Date: 23 March 2023
Our Ref: 23/00254/AGR
Please ask for: Mike Halsall

Invalid Application

Proposal: General purpose agricultural building for fodder, machinery and equipment storage
Location: Wilcocks Farm Dean Head Lane Rivington Bolton BL6 7SJ
Reference: 23/00254/AGR

Agricultural Building at Wilcocks Farm, Dean Head Lane, Horwich, Bolton, BL6 7SJ  
D R Wood March 2023  
Block Plan 1:500 @ A4

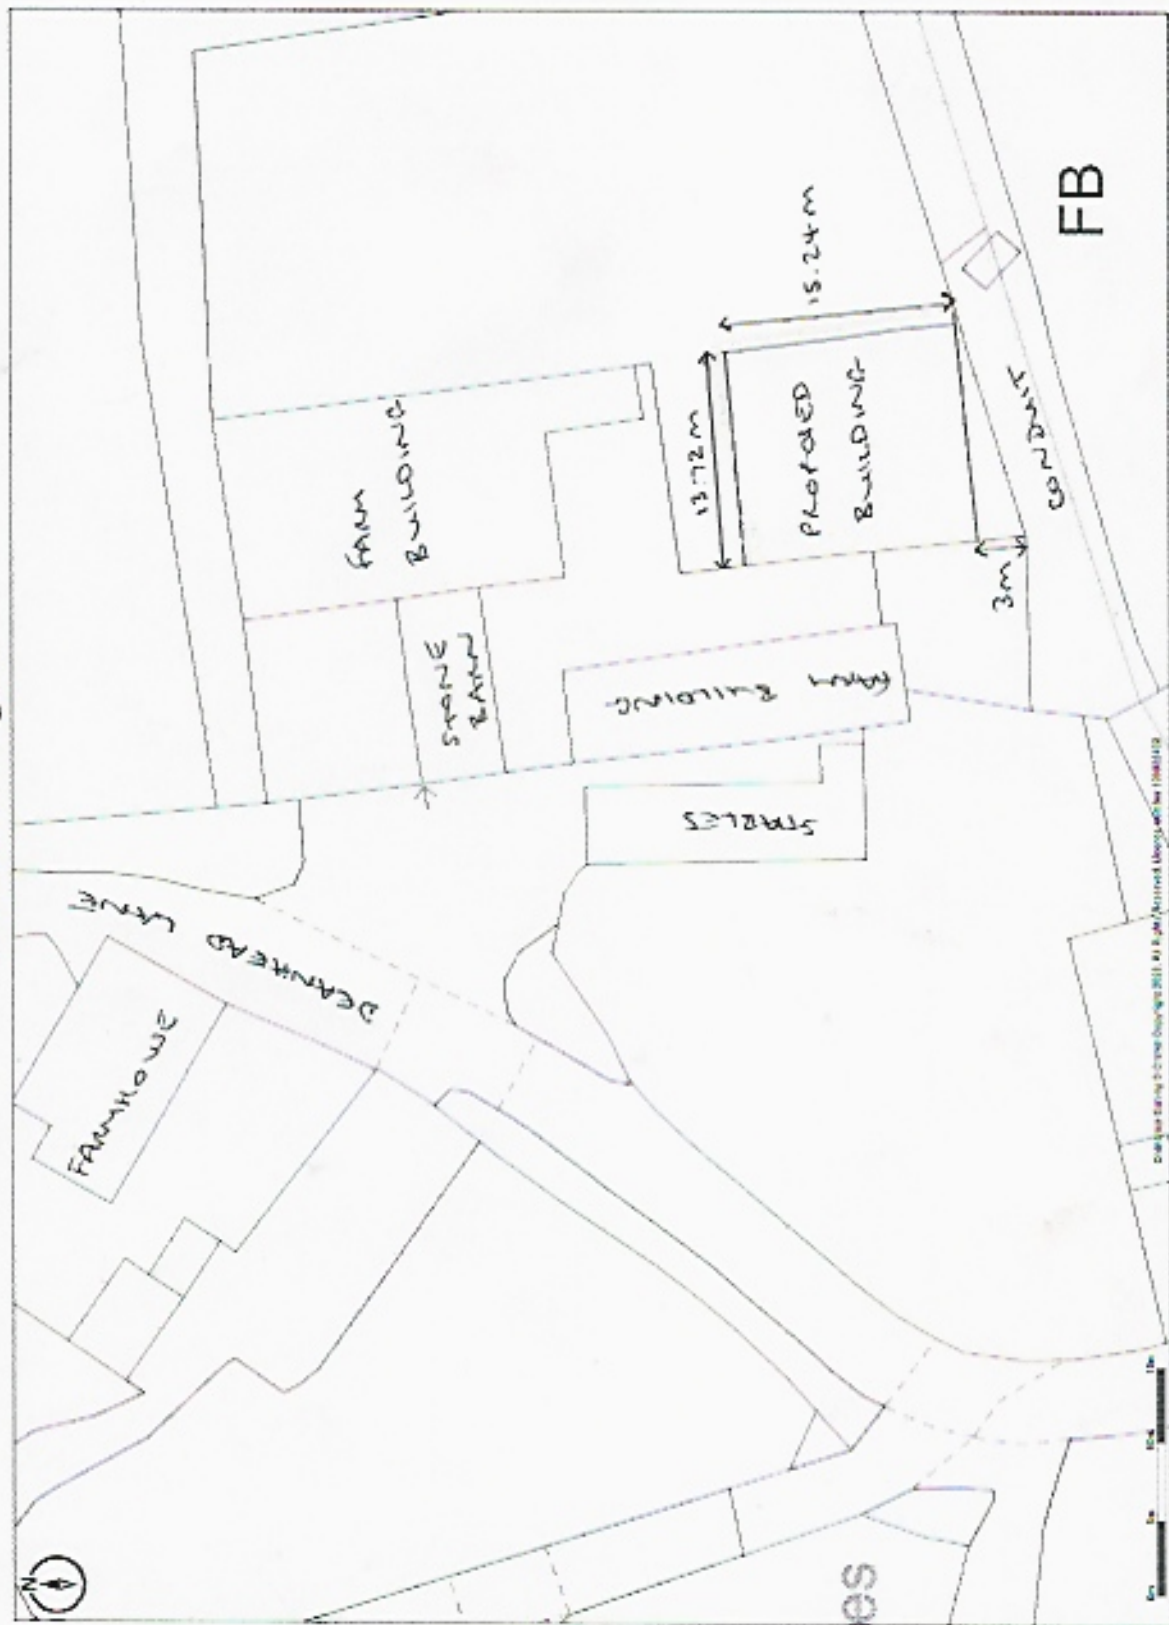
1. The location plan is unclear – the wording is illegible and the image is blurred. Please provide a clear and up-to-date map.
2. Further information on the agricultural operation – please see Section 37 of the Council's validation checklist - [Validation \(chorley.gov.uk\)](https://www.chorley.gov.uk)
3. The block plan does not show road names. Please provide an updated plan.
